Updated Information for Review for 422 Hillandale, BRES2507-0043.

Overhang Detail - Post

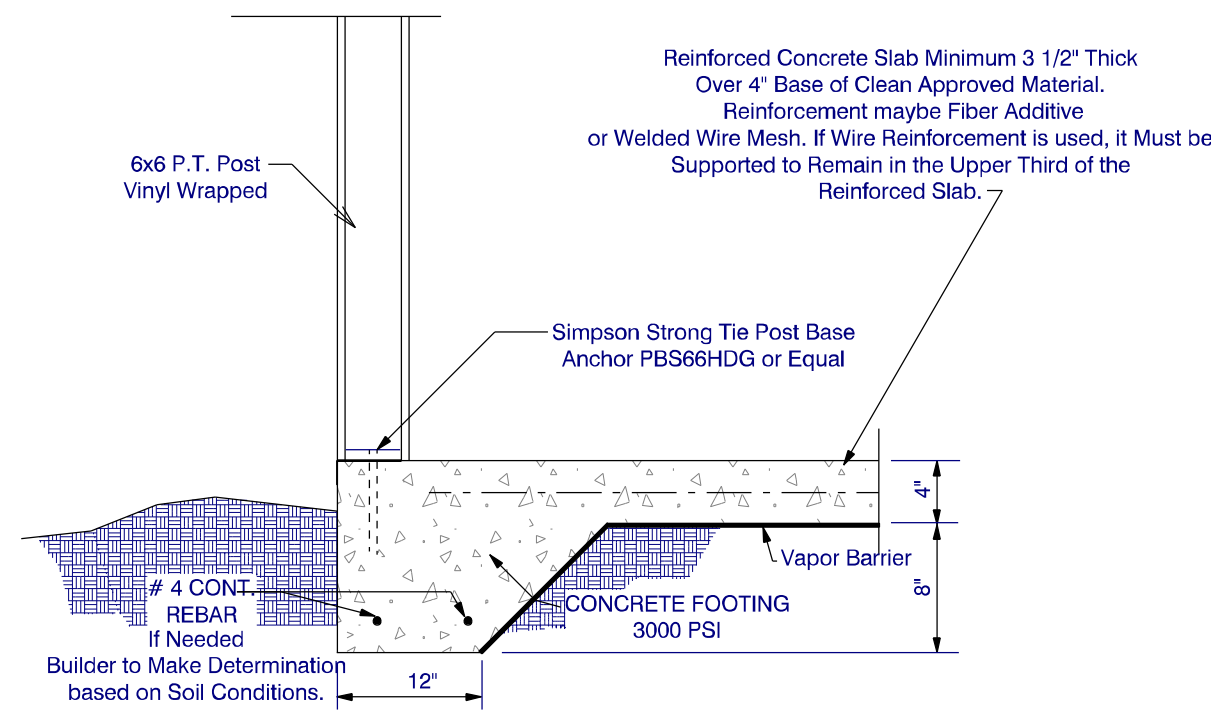
1. There will be no trusses as we will be stick building the addition to the home.
2. I have attached a revised drawing to include the patio beam size. It will be a double 12" LVL.
3. The headers above the triple window on the Left Elevation of the home will be built to NC Residential Building Codes in sections 600 & 800 span charts and will have a double 2x10 header, double king and double jack stud to support window opening.
4. The window and sliding door on the Rear Elevation of the home are non-load bearing and will also be built to the NC Residential Building Codes sections 600 & 800 and will have a header of a double 2x10 with standard king and jack studs to support openings.
5. There is one other beam in the addition at the kitchen which is labeled on the plans previously submitted as a 14" LVL and that will be completed per the plan details.
